permit application 2017 01226

Bruce Little 55 Glen Haven Rd

# Foundation Drawing From Mike Paul Foundations

PROPOSED MUDROOM  
8' x 12' 96 S.F. ±

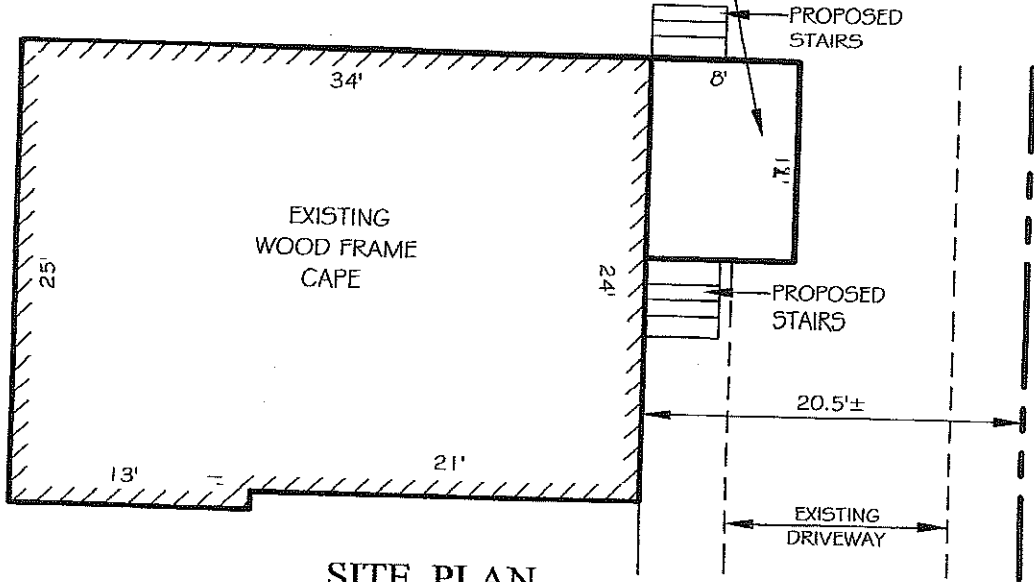
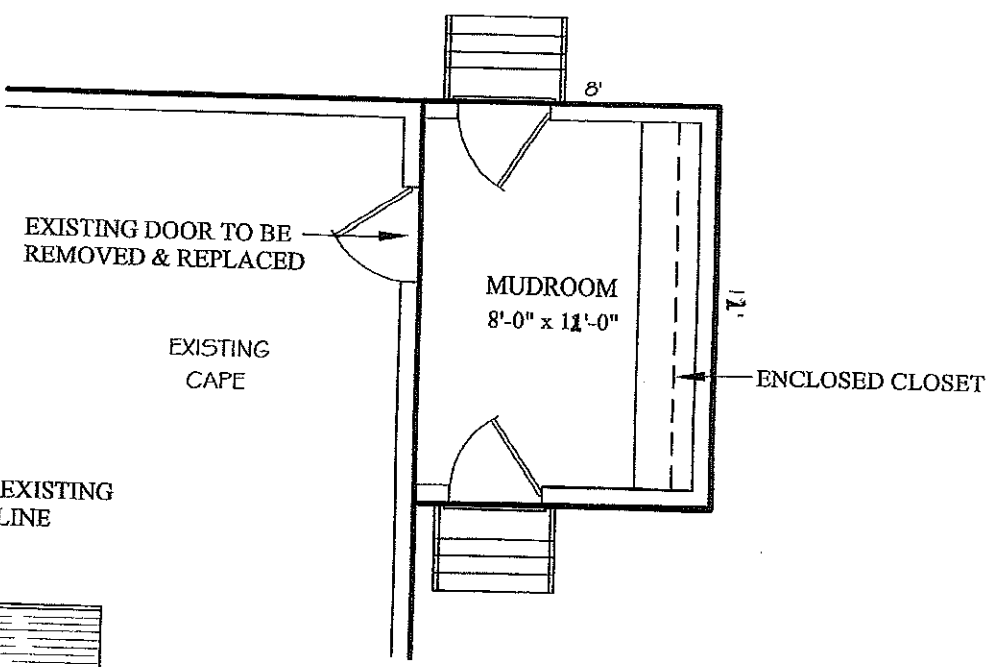
Show under floor space venting and —  
access as per IRC Section R408

Show under floor space venting and access as per IRC Section R408. per IRC R408 code ventilation openings shall not be less than 1 square foot for each 150 square feet of under floor space. We have 96 square feet therefore we will be cutting a 1 square foot opening from the new addition into the current basement for airflow and access.
